**Consultation Response from Mike Hibbert,
KC Waste Strategy(Refuse & Recycling)**

2023/90909 adj, 115, Westfield Lane, Wyke, BD12 9LY

Reserved matters application pursuant to outline permission 2020/90436 for demolition of 1 dwelling and erection of residential development and associated works with details for access

Responding Ref: WPN 23-019

Client:	Yorkshire Choice Homes Limited		
Westfield Lane, Wyke SITE PLAN AND LOCATION PLAN			
Scale:	1:1250 1:200 @ A1	Date:	Feb 23
Drawing Number:	2023-018-001	Revision:	N
			Drawn by: DCK/KLU

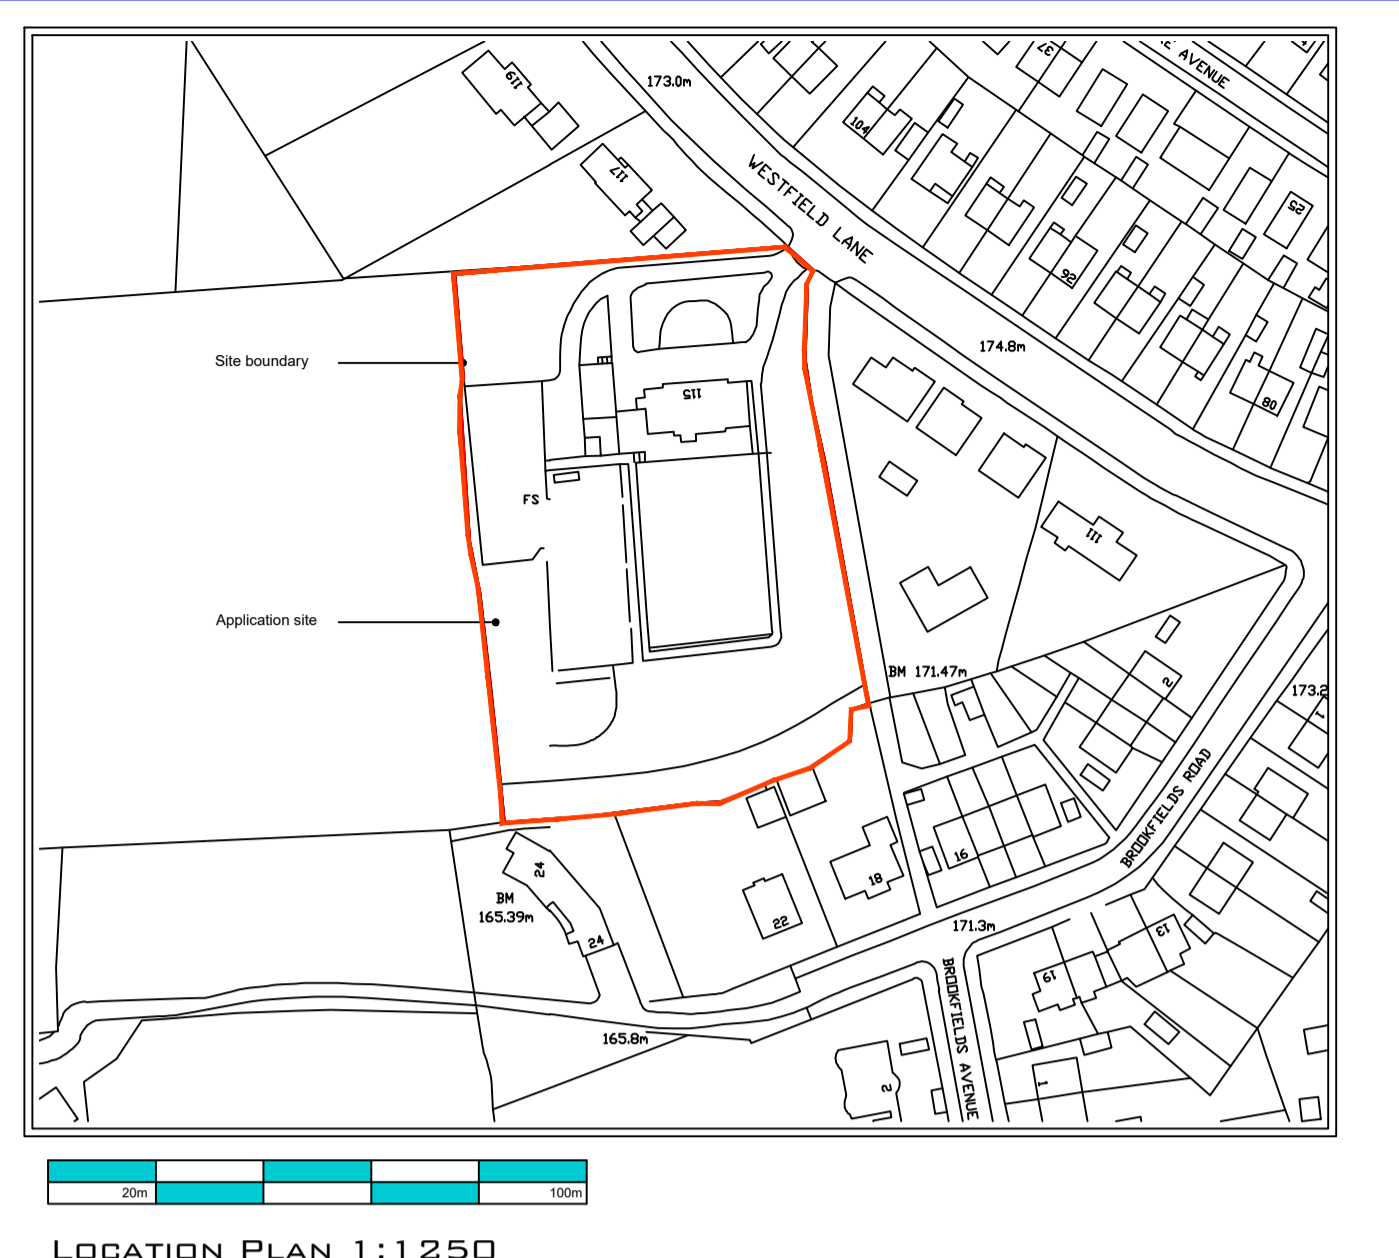
- The applicant has submitted Site plan & Location Plan Ref 2023-018-001 Rev F dated 11/04/2023. The plan shows 15 properties with a mix of eleven detached and four semi-detached properties with each dwelling having a private rear garden.

- It is welcomed that the plan shows space has been provided at the rear of each property (except for Plot 1) for 3 x 240ltr bins, (1x240ltr Residual, 1x240ltr Recycling and as the properties have gardens the space to accommodate a third bin for garden waste), with paths/ gates 900mm wide to enable access from the rear gardens to the highway.

- Plot 1 appears to have restricted access to the rear garden due to steps/ topography. It may be necessary to locate a bin store at the front of the property. If this is the case, bin storage should avoid keeping bins under windows/close to doors. Any such storage would be set within the Streetscene and therefore should be screened and secured to prevent bin blight, the spread of waste into the street, unauthorised use and theft/damage to bins.

- The plan key is annotated next to the bin icon with (BC denotes Bin Collection Area) but there does not appear to any locations shown on the plan. It is important to ensure that bins do not cause obstruction to pedestrians or other highways users when presented for collection, particularly where space requires these to be left in clusters. Bin presentation space should be identified for each plot, on a hard surface and where a refuse collection vehicle (RCV) can be easily reached.

- Plots 9-13 appear to be located on a private drive. Shared private drives will require communal presentation points for bins. These must be large enough for the number of bins to be collected and be on level, hard surfaces such that grouped bins do not cause obstruction to the highway, drives or pedestrian movement on collection day. The footprint dimensions for storage and presentation points of a 240ltrs wheeliebins is 940mm x 780mm.

- The drag out distance to the BCP from plot 11 is on the limit of the maximum 25m specified in guidance BS5906:2005.
- Reversing of Refuse Collection Vehicles (RCV's) causes a disproportionately large number of moving vehicle accidents in the waste/recycling industry. Injuries to collection workers or members of the public by moving collection vehicles are invariably severe or fatal. BS 5906: 2005 recommends a maximum reversing distance of 12 m. The reversing distance from within the turning head to a potential BCP to serve collection from Plots 9-13 is approximately 20m.

- Suitable site access and manoeuvrability space for a Refuse Collection Vehicle is vital to the Council's ability to discharge its obligation to collect waste from domestic properties. This obligation will exist in perpetuity on any residential development and as such will be a critical consideration in the layout of the site if approval is granted. Confirmation is required that the turning head in front of Plots 3-4 is of an appropriate size.

- Where turning is necessary, the turning facilities must be demonstrably sufficient for an 11.22m refuse collection vehicle and opportunities for parking in the turning area must be designed out. Swept path analysis must show the manoeuvrability of this vehicle throughout the site, demonstrating the safe passing of other vehicles likely to be using the road – either parked or moving.

- Angular road shapes such as that shown in the turning heads and driveways present difficulties for street cleaning and are a common area for litter and dirt to accumulate.
